# **KITTITAS COUNTY**

## **DEPARTMENT OF PUBLIC WORKS**

**TO:** All Staff  
**FROM:** Public Works Plan Review Team  
**DATE:** June 25, 2024  
**SUBJECT:** SPF-24-00006 NH2G

NH2G SHORT PLAT
PART OF SECTION 16, T. 17 N., R. 20 E., W.M.
KITTITAS COUNTY, WASHINGTON

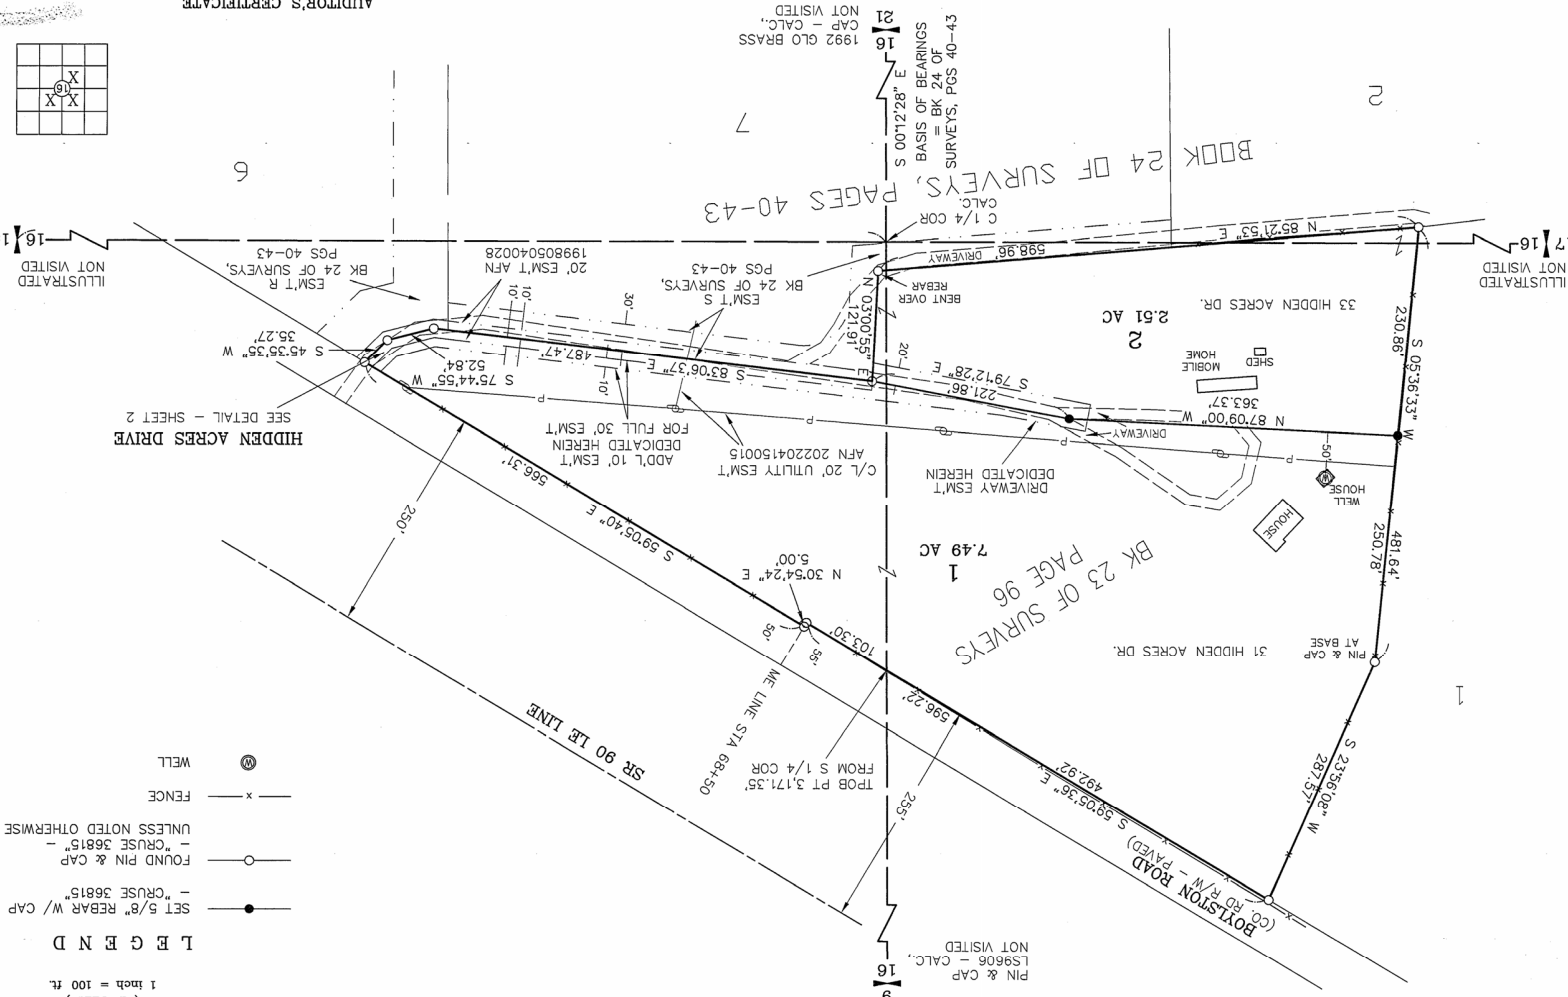
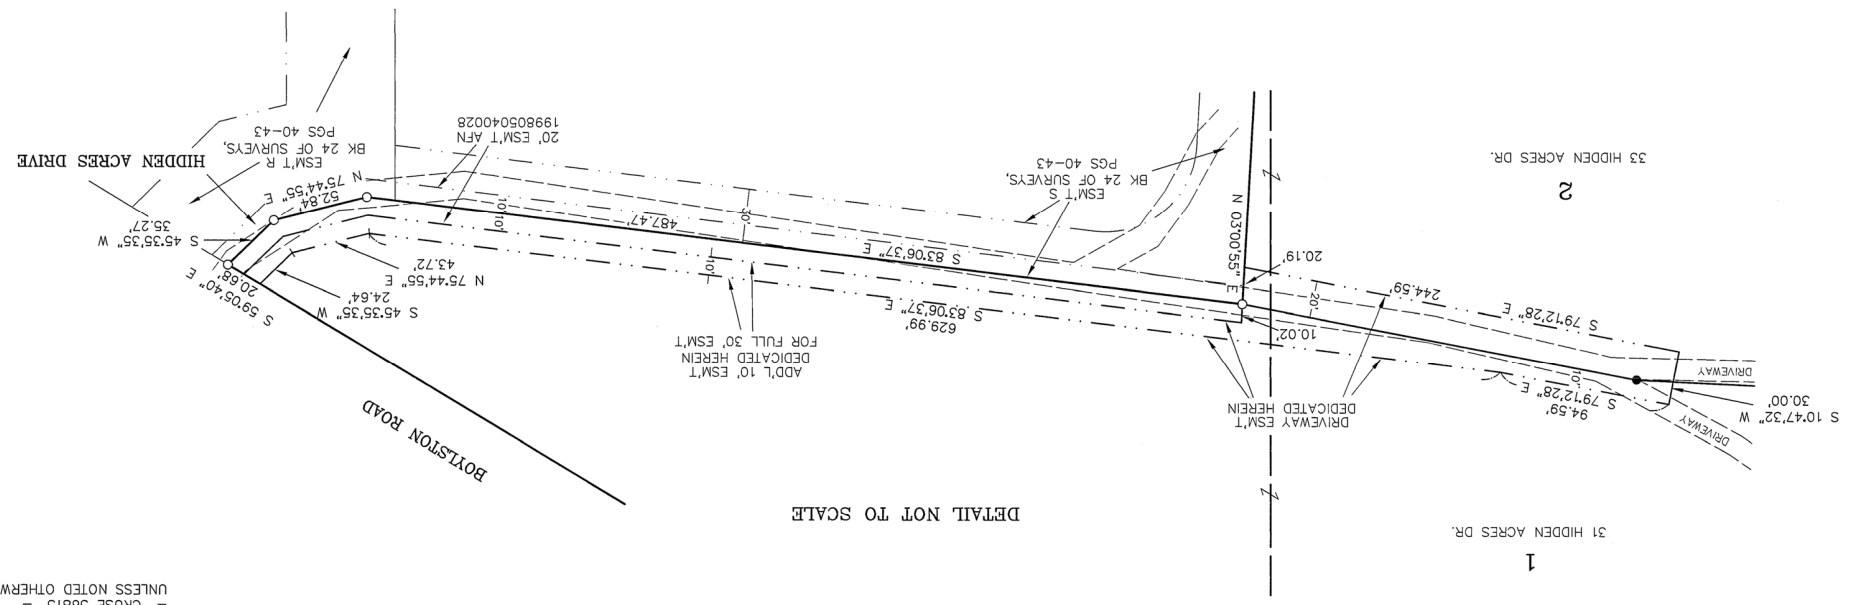
<b>ACCESS</b>	<b>OF NOTE:</b> Existing addresses need to be assigned to the correct parcel upon filing the short plat with the Assessor's Office. (JS)
<b>ENGINEERING</b>	Except as exempted in KCC 14.05.060, no grading or filling upon a site involving more than one hundred (100) cubic yards shall be performed without a grading permit from the County Engineer or Public Works designee (KCC 14.05.050). An application for grading in excess of five hundred (500) cubic yards shall be accompanied by an engineered grading plan (KCC 14.05.080). (CP)
<b>SURVEY</b>	<ol style="list-style-type: none"><li>1. Within the legend, it appears that the Found Pin &amp; Cap description has been shortened.</li><li>2. Within the legend, Please specify which Record Data in Brackets is being referenced OR show it at the label location. (appears to only be at the Basis of Bearing, AFN549373).</li><li>3. Please label Hidden Acres Drive. This is just as topographic information to assist in locating the survey, and does not need width or ownership.</li><li>4. The access easements should be shown within their own detail window for clarity. Within this detail, please include suitable dimensions to be able to retrace the 30' driveway easement, as well as the Westernmost extent of the additional 10' Easement.</li><li>5. Note 4 calls out basis of bearing and additional survey information in Book 23 of Surveys, Page 96. I believe that while B:23, P:96 contains additional survey information, the Basis of Bearings should be per B:24, P:40, as referenced elsewhere on the survey. (JT)</li></ol>
